City of Albuquerque Stormwater Construction Site Inspection Report

ESC File No.	A11E017C	Project Name:	Tidal Wave Care Wash		
NPDES Id. No.	NIMR1005J2	Location:	10601 Unser Blvd		
5/8/2023	Owner	Contractor			
Operator	TWAS Properties LLC		Scarsgard Construction		
Contact name & title	Ryan Crumley		Jason Skarsgard		
e-mail	ryan.crumley@twavelead.com		jason@skarsco.com		
Contact Phone #	706-647-0414		262-2323		
COA Inspector	Doug Hughes		Start/End Time:	10:30AM	
Construction Phase:	Graded Lot 2 no construction active, lot is disturbed				
Type of Inspection:	<input type="checkbox"/> Regular	<input type="checkbox"/> Storm Event	<input type="checkbox"/> Post Storm Event >0.25"	<input type="checkbox"/> 311/Complaint	<input checked="" type="checkbox"/> Follow Up
Weather at time of inspection?	Clear		Temperature: ~	60	
Estimated date of last storm 0.25" or greater	3/16/2023

SILT FENCE

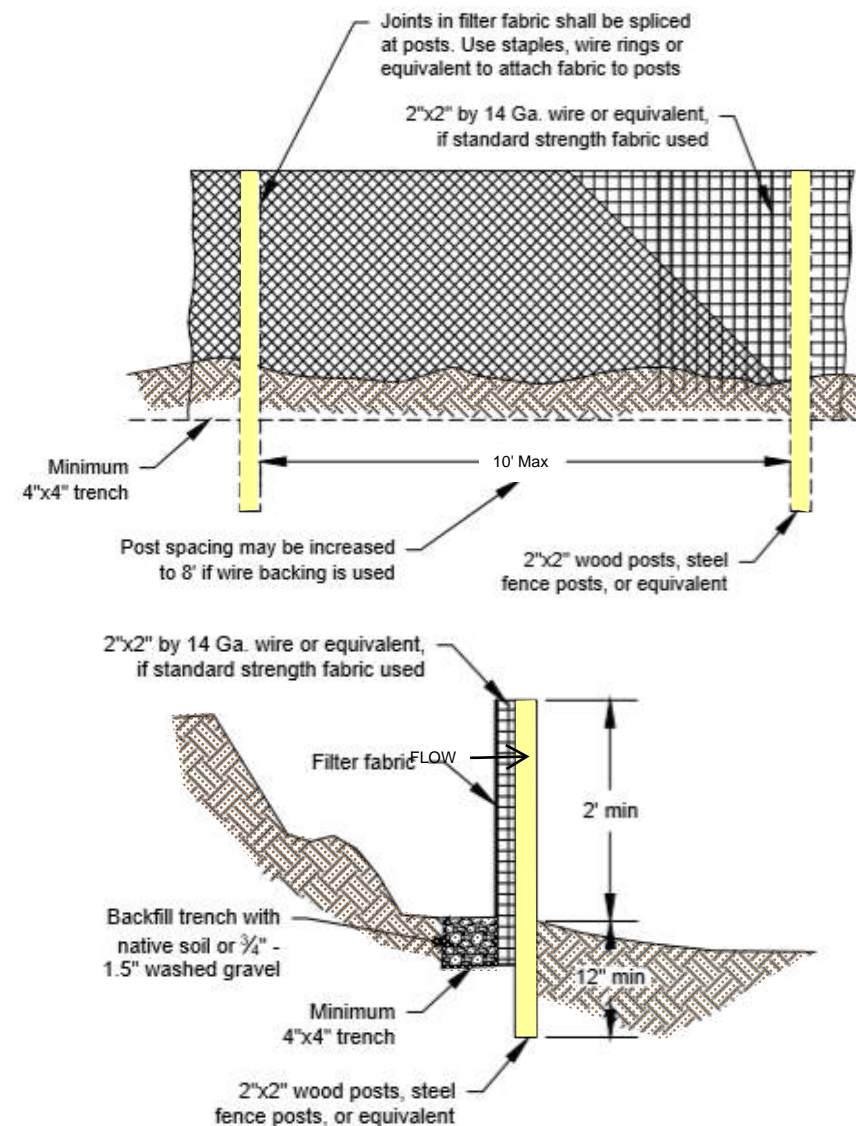
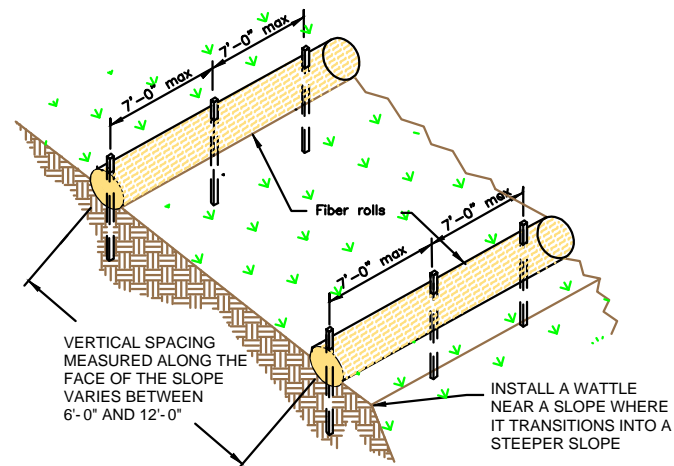
Item Number	Deficiency/ Corrective Action				
1	Posting sign is laying on the ground and must be replaced				
2	Silt Fence is down in the North east corner and must be reset. It is full of sediment and needs maintained in several other places.				
3					
4					
5
